Memorandum

To:	Linda Pineau	Date:	January 6, 2023
From:	April Ng		
Project:	Butenwieser/Wiley Residence 6838 96 th Ave SE Mercer Island, WA 98040 King County APN 302405-9010	File No:	2205-199
Subject:	Building Permit Review SUB2 Response

The comments are restated below, followed by responses. Updated drawings have been clouded with Revision 2: 1/6/23 Building Permit Resubmittal.

G000

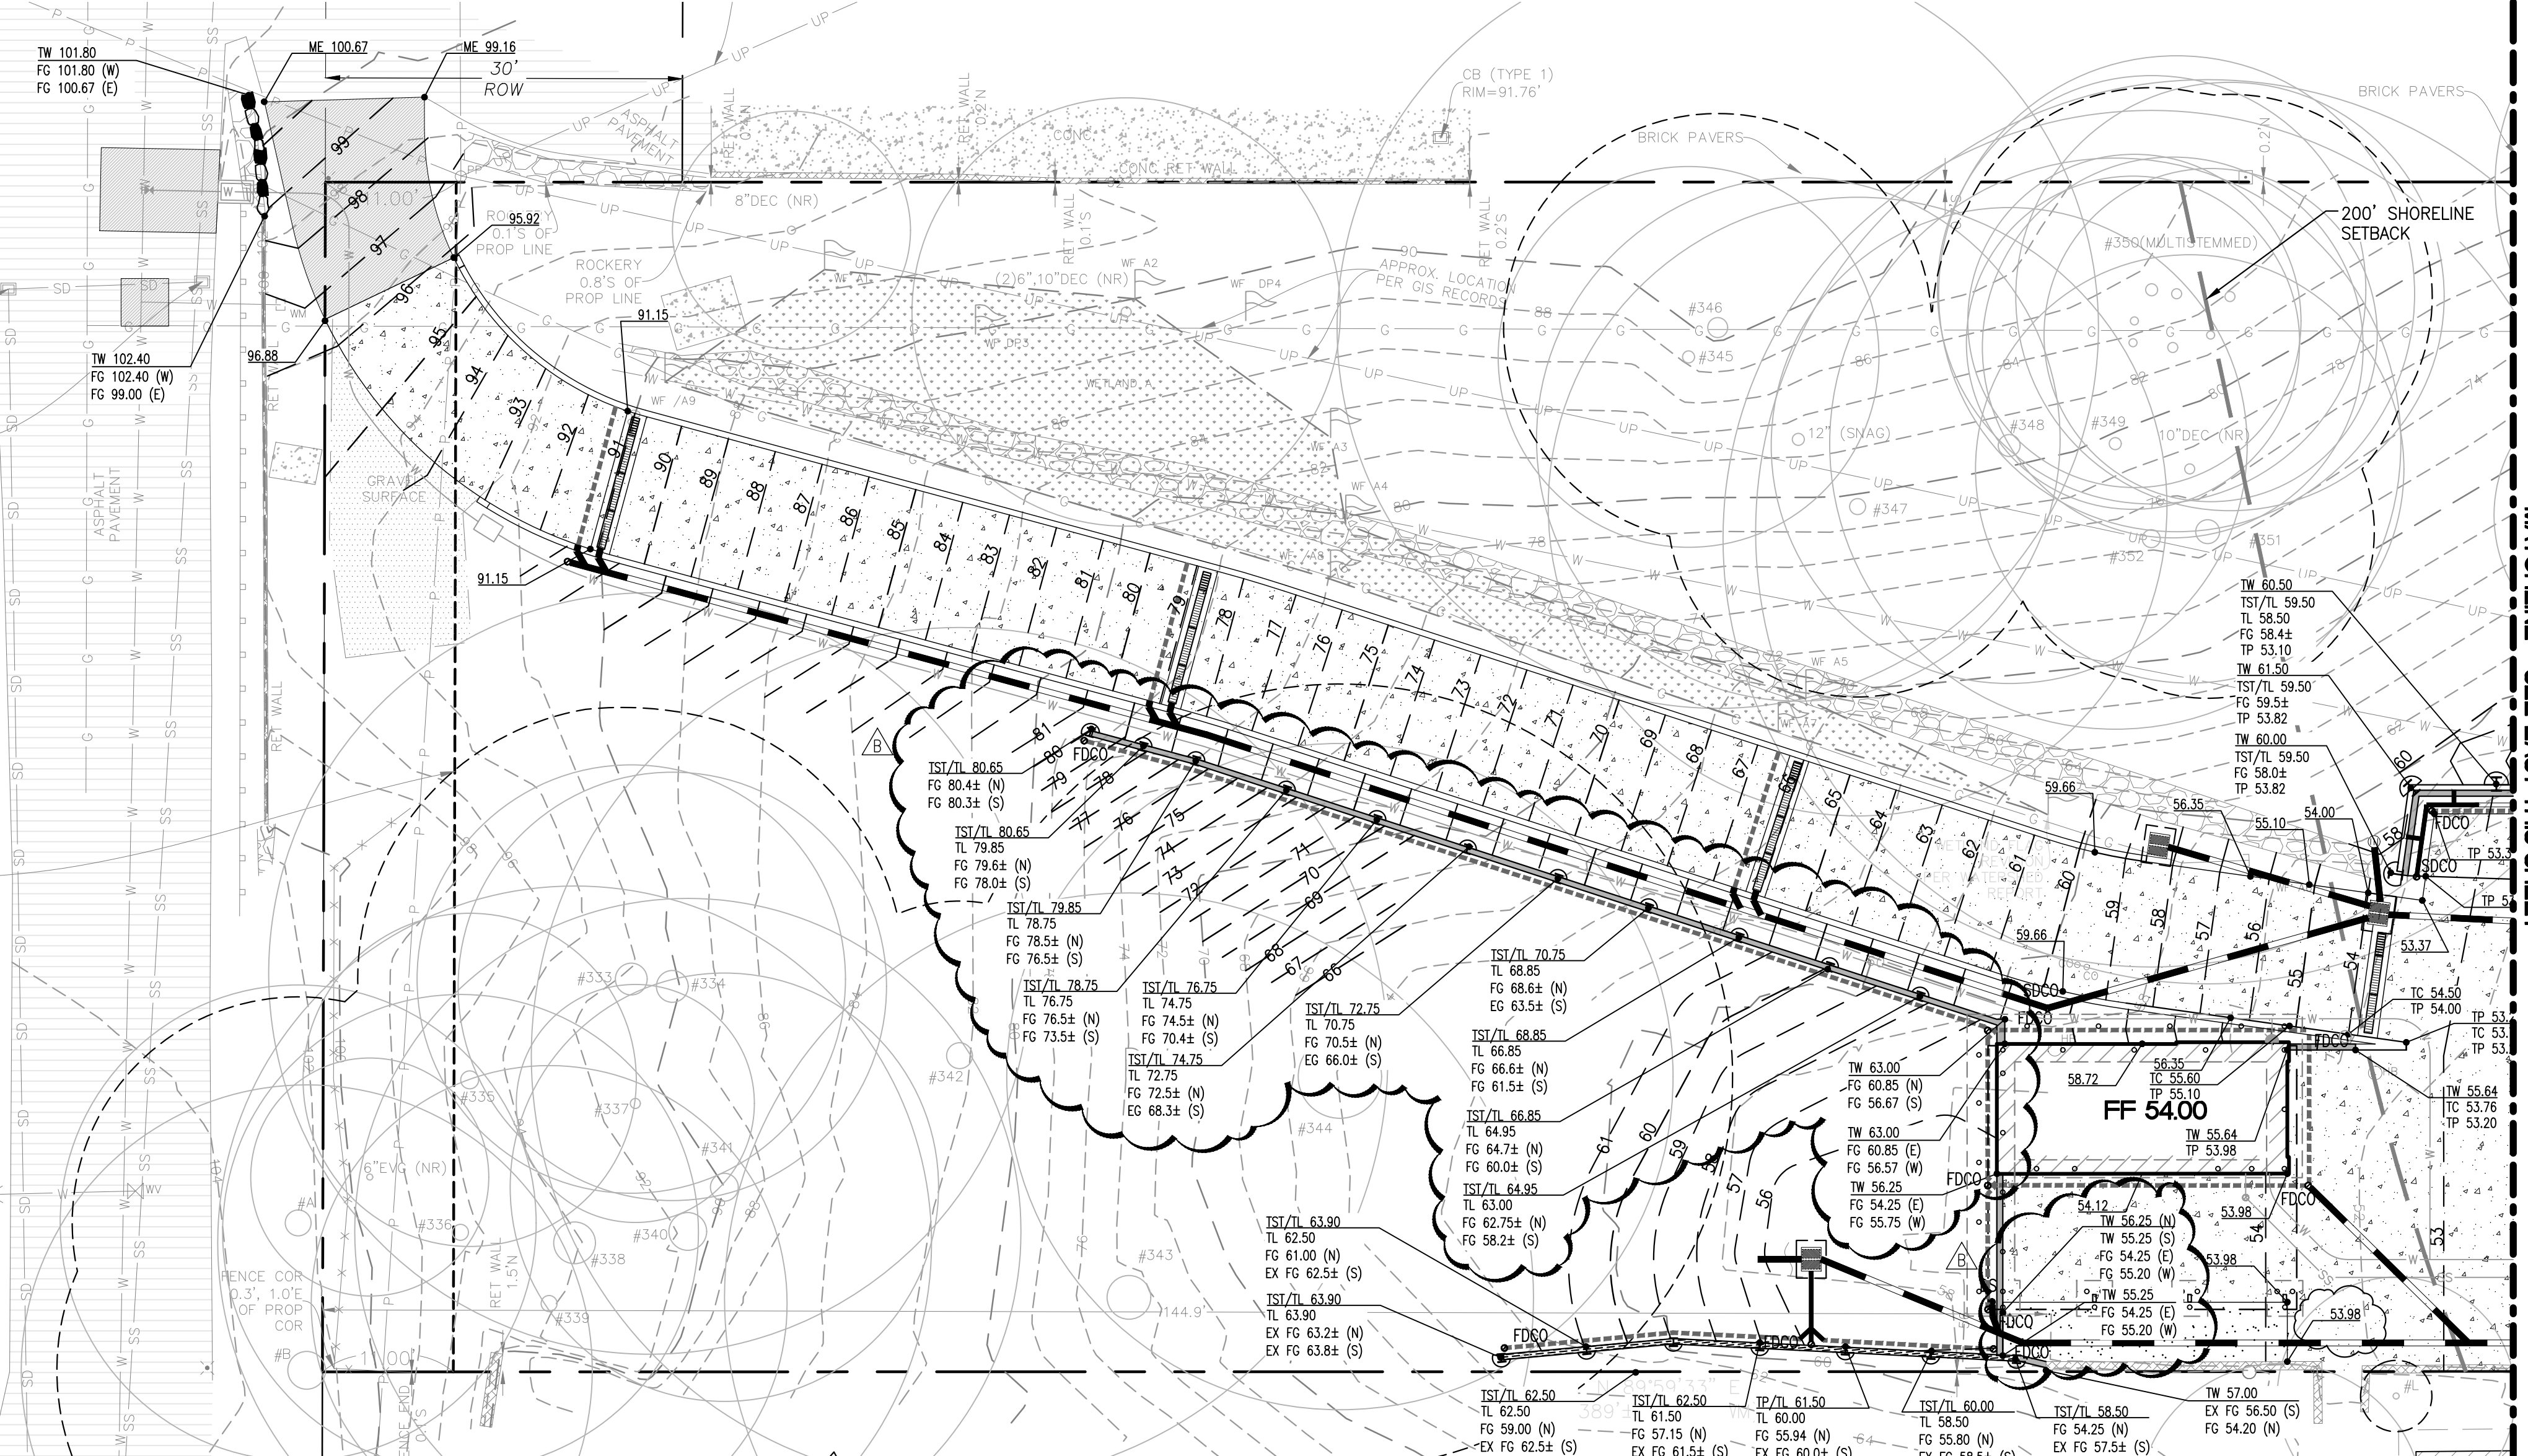
<p>Not an ADU Affidavit needs to be recorded. Provide recorded document or recording number.</p>		
<p>G000 <i>Unresolved from SUB1</i></p> <p>This is a large lot per MICC 19.02.020(I). Please show compliance with one of the options in this section.</p> <p>We need to see the recorded document.</p>	<p>Recording number has been provided on G000 and a copy of the recording has been uploaded with the building permit resubmittal.</p>	<p>G000</p>

<p>A202</p> <p>Show maximum downhill facade height on all applicable elevation drawings.</p>	<p>Datum was added for top of exterior wall façade. References to view 1/A202.</p>	
<p>G000 <i>Unresolved from SUB1</i></p>	<p>Recording number has been provided on G000 and a copy of the recording has been uploaded with the building permit resubmittal.</p>	<p>G000</p>

C200A

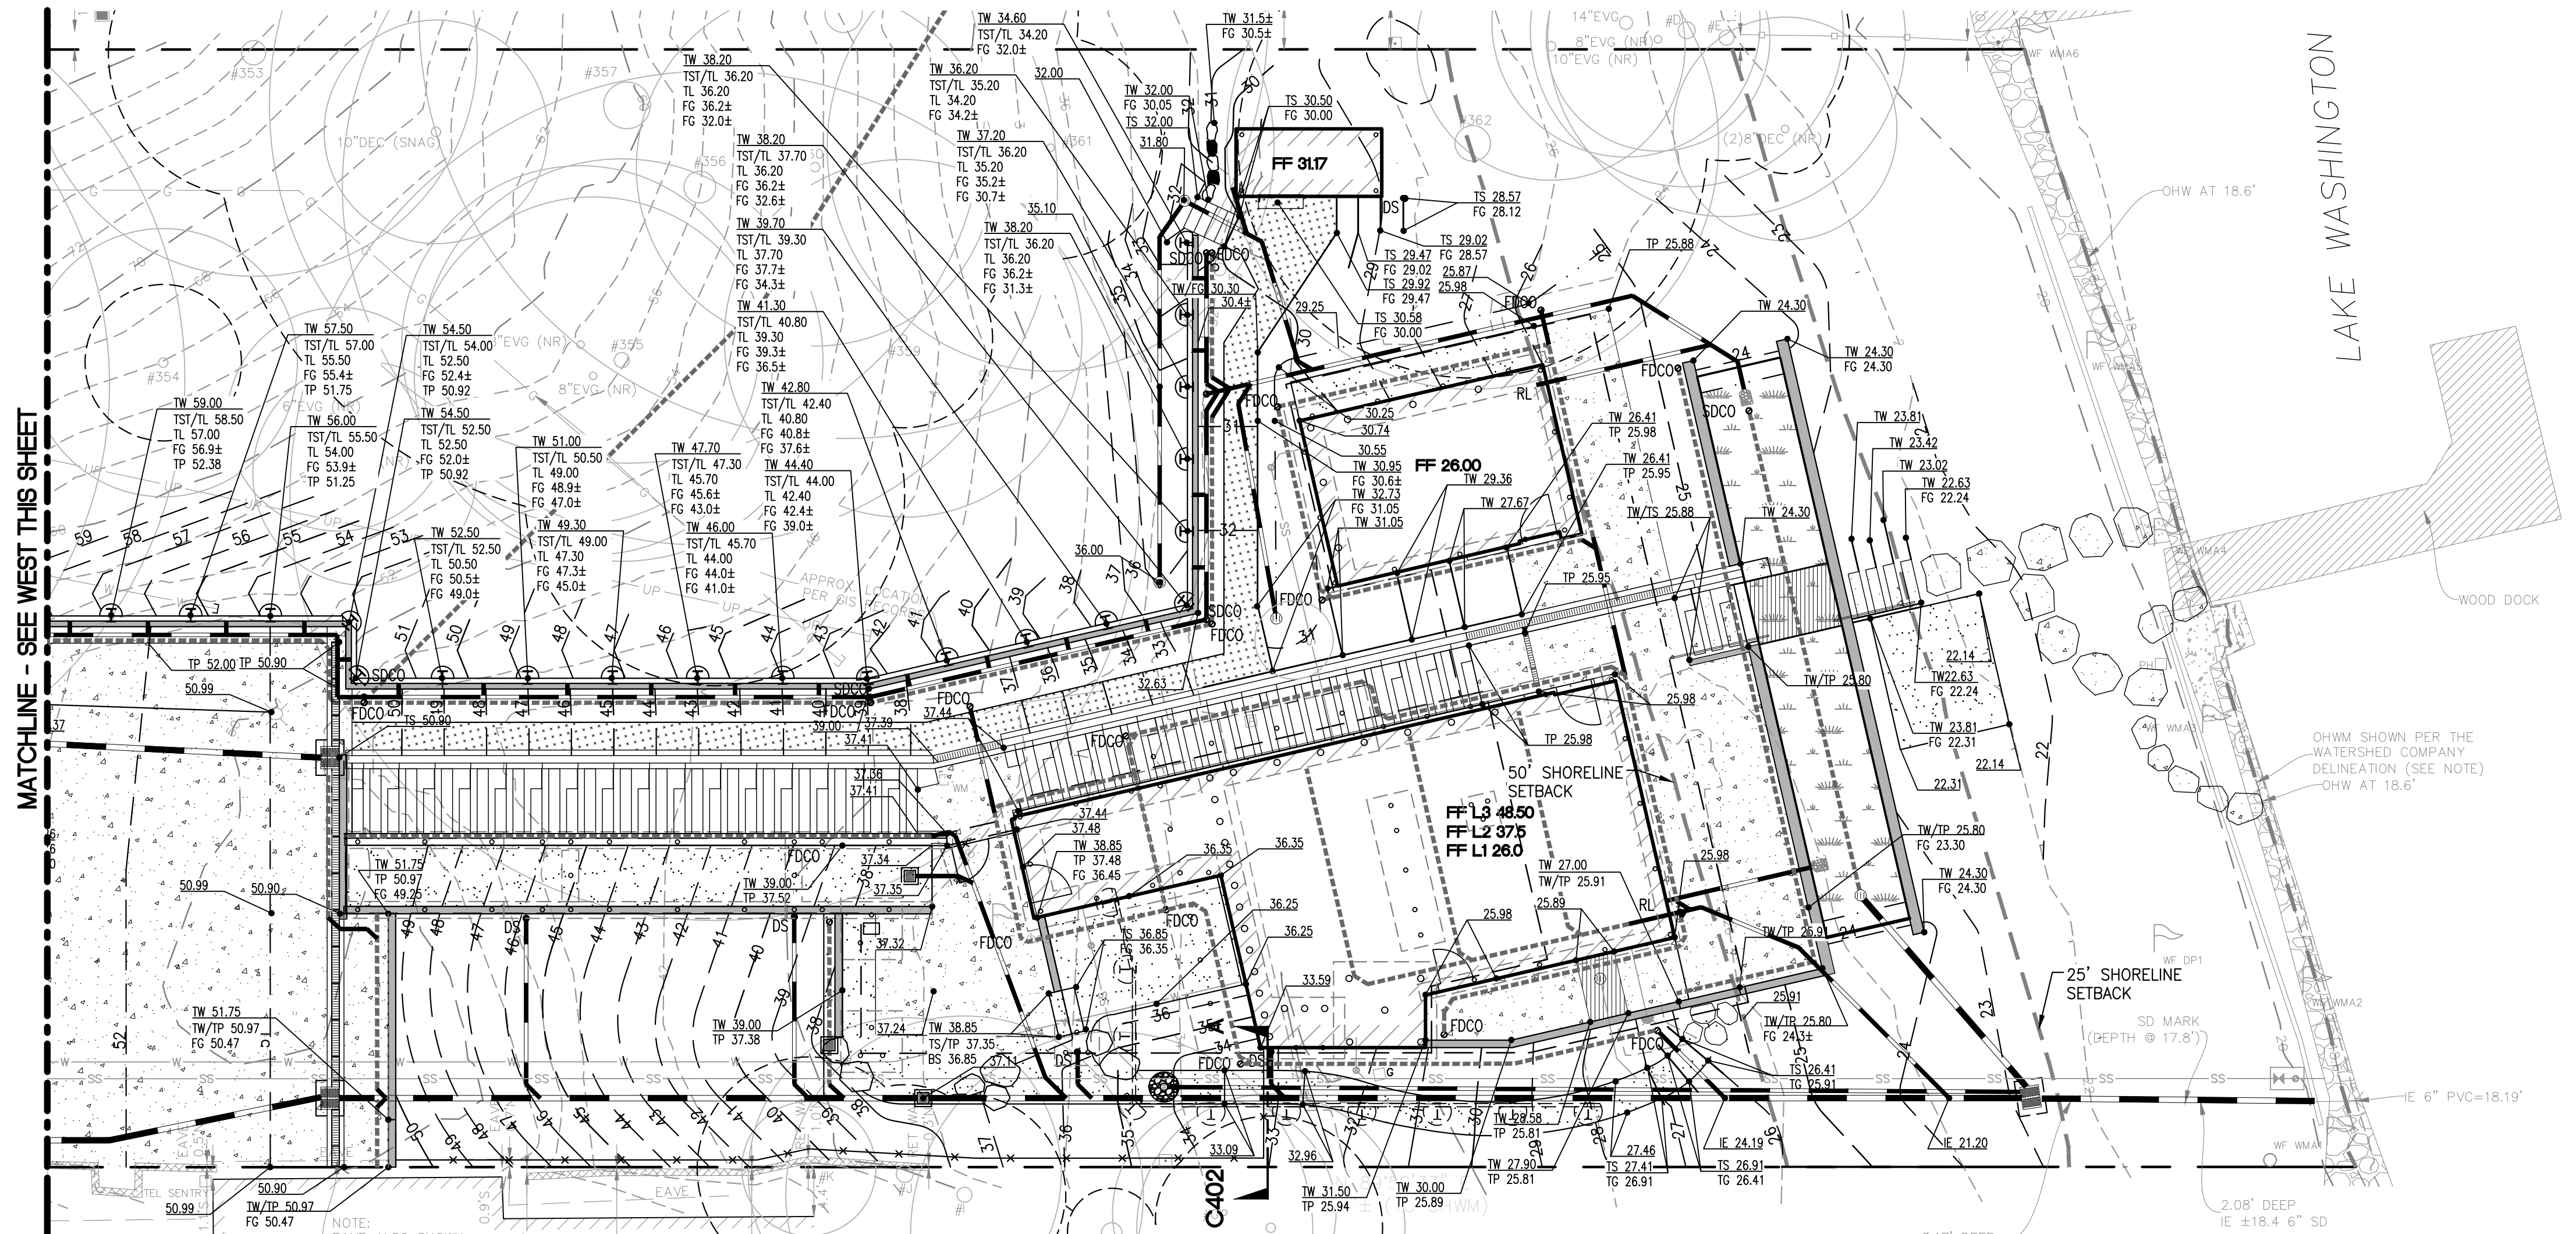
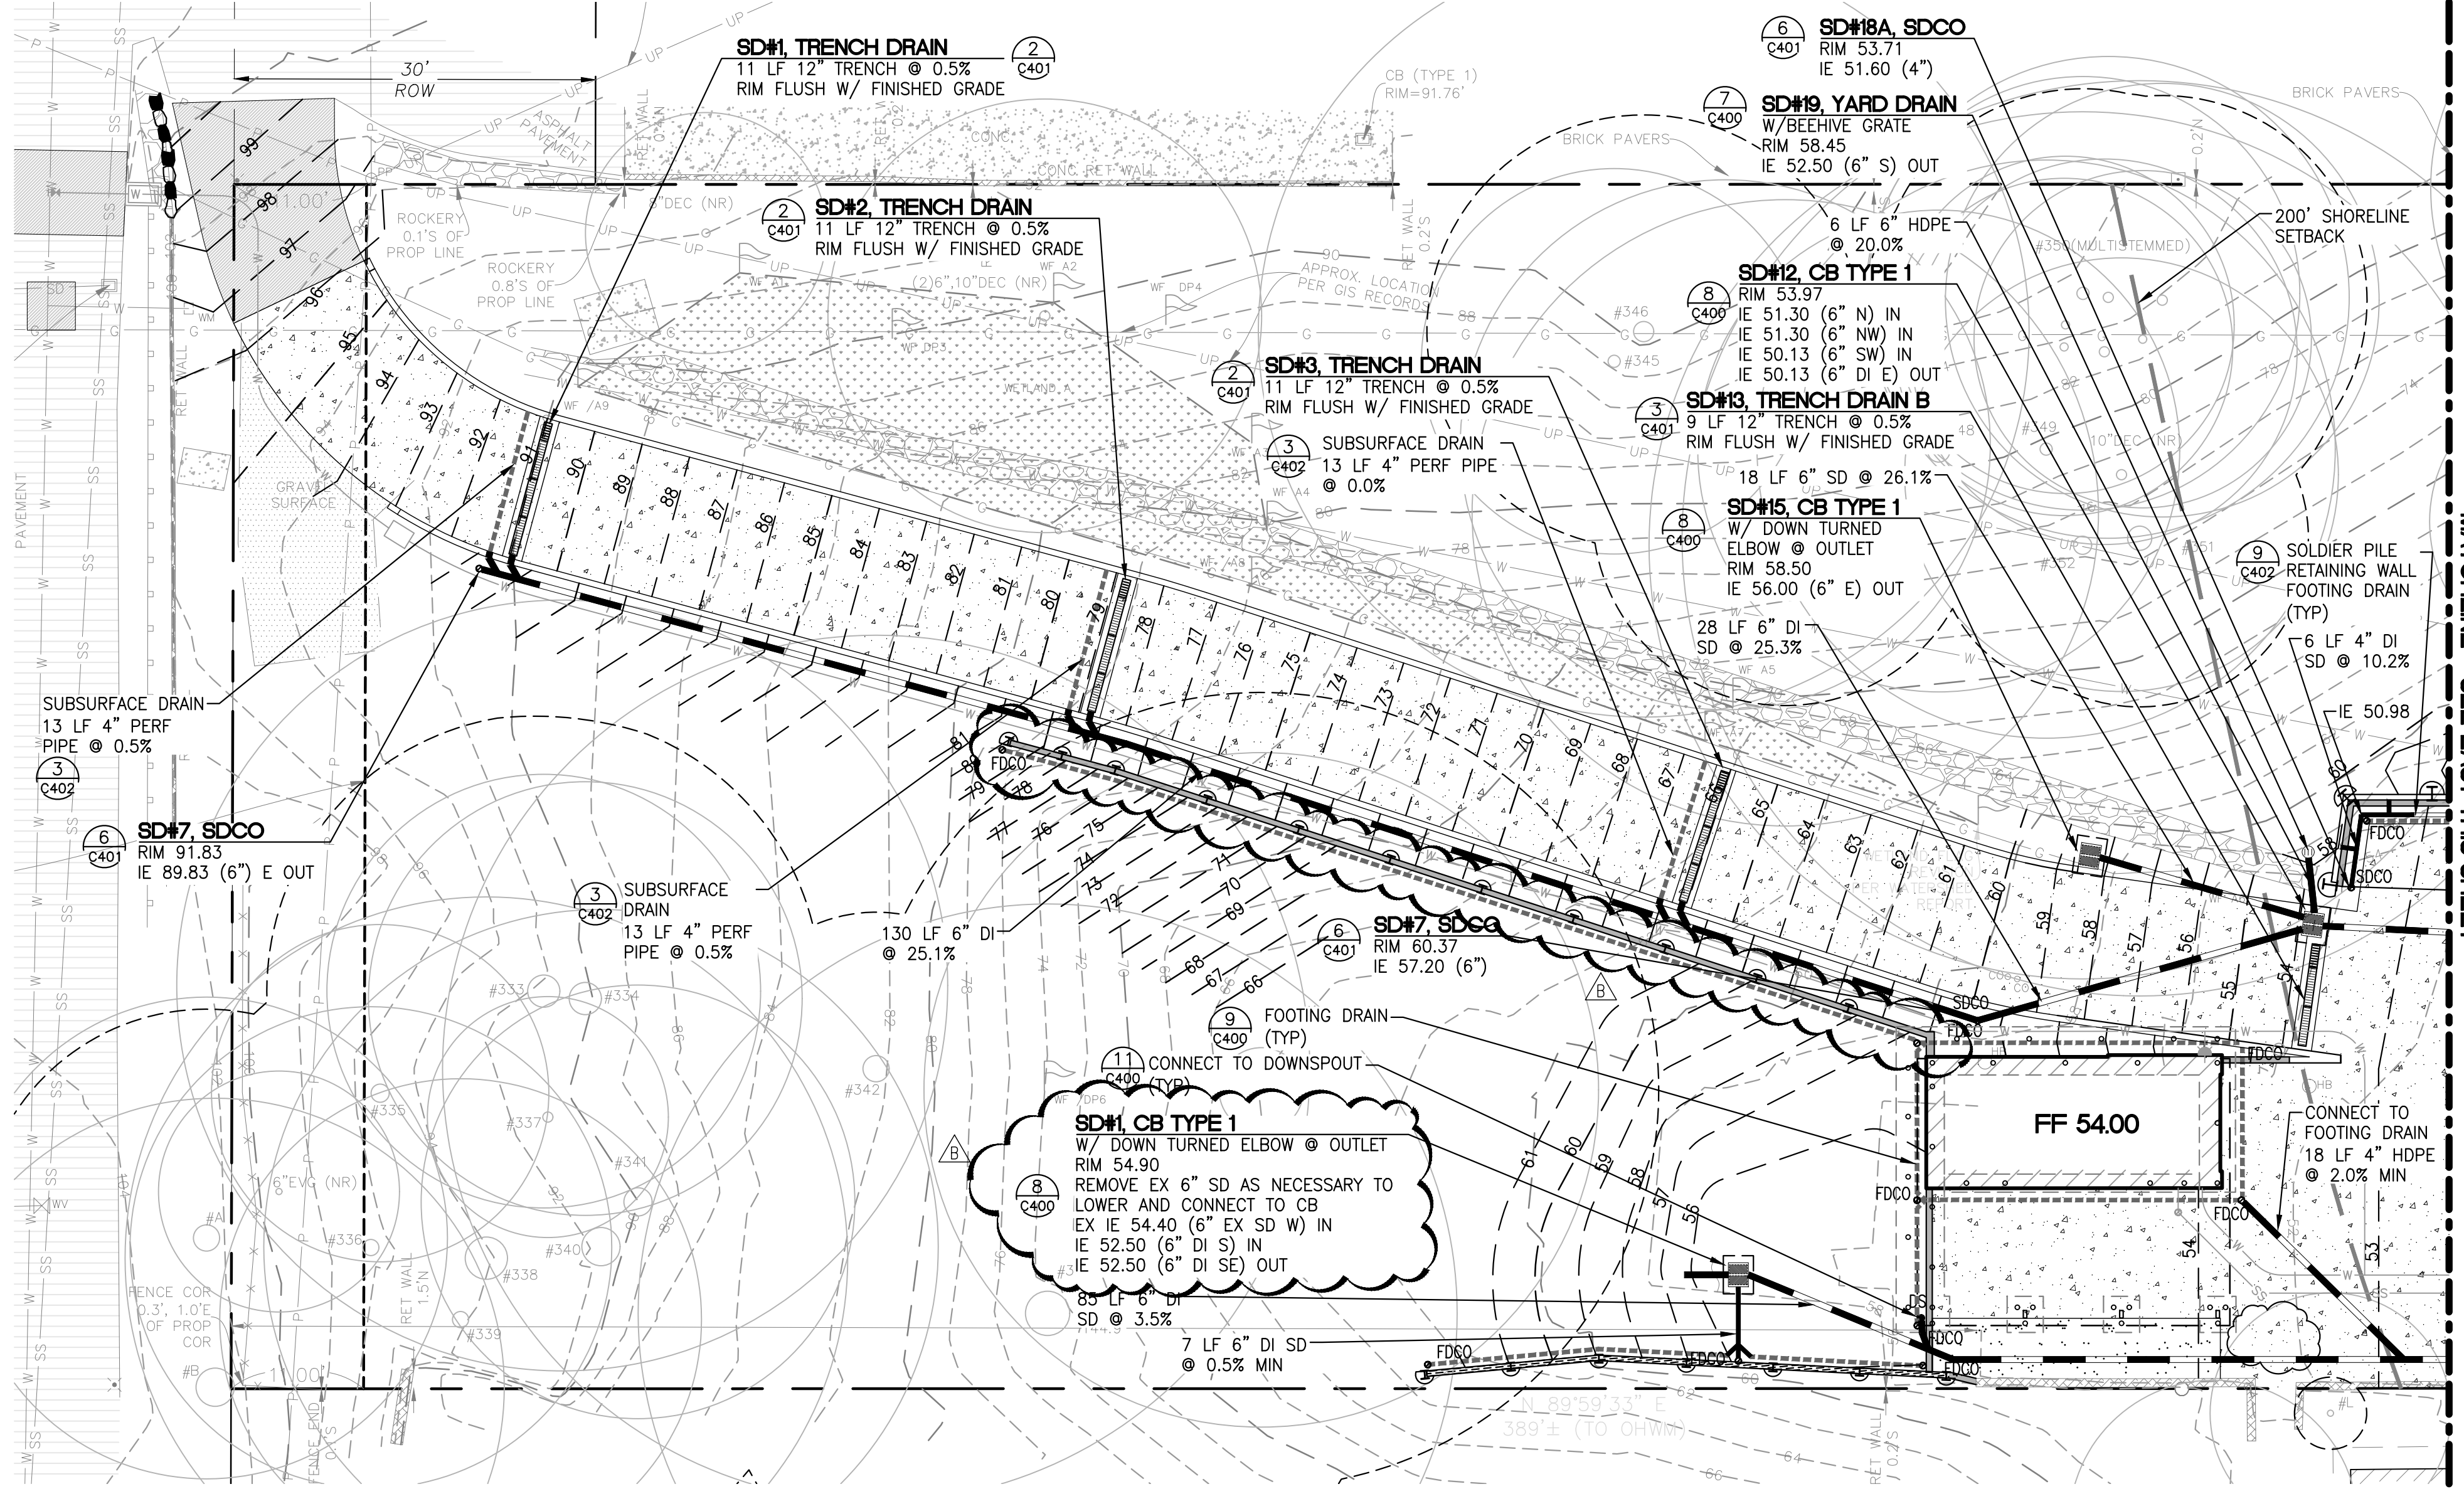
<p>Geotechnical Peer Review</p>		
<p><i>Comment</i></p>	<p><i>Response</i></p>	<p><i>Document Ref.</i></p>
<p>C200 SUB 1 Comment: Geotechnical engineer to review temporary open cut required at this location. The recommended temporary open cut angle of 1.5H:1V in the geotechnical report would appear to encroach on the adjacent property. Provide recommendations on how to accomplish this excavation. Provide a section detail for clarification.</p> <p>SUB 1 Response: Author: April Ng (ang@millerhull.com) The geotechnical addendum dated April 26, 2022 (Revised August 16, 2022) includes recommended temporary shoring information.</p> <p>The structural foundation at the building has been revised to reduce the extent of temporary shoring along the southern property line. Reference S112, 3/S303.</p> <p>SUB 2 Comment: Please show location and extent of proposed temporary shoring. Please provide type of shoring, wall heights, details and calculations to support proposed design.</p> <p>Please show in a section for clarification the location of the proposed storm drainage installation and how proposed tree protection</p>	<p>Location and extent of proposed temporary shoring has been included on sheets S410 and S411. Details and structural calculations have been provided.</p> <p>Proposed storm drainage installation and proposed tree protection information has been included on 8/C402.</p>	<p>S410, S411, 8/C402</p>

will be accommodated with the proposed temporary shoring.		
C200 It is unclear where section A-A' is located. Please provide plan sheet reference and section.	Please Reference 8/C402	8/C402 Section A
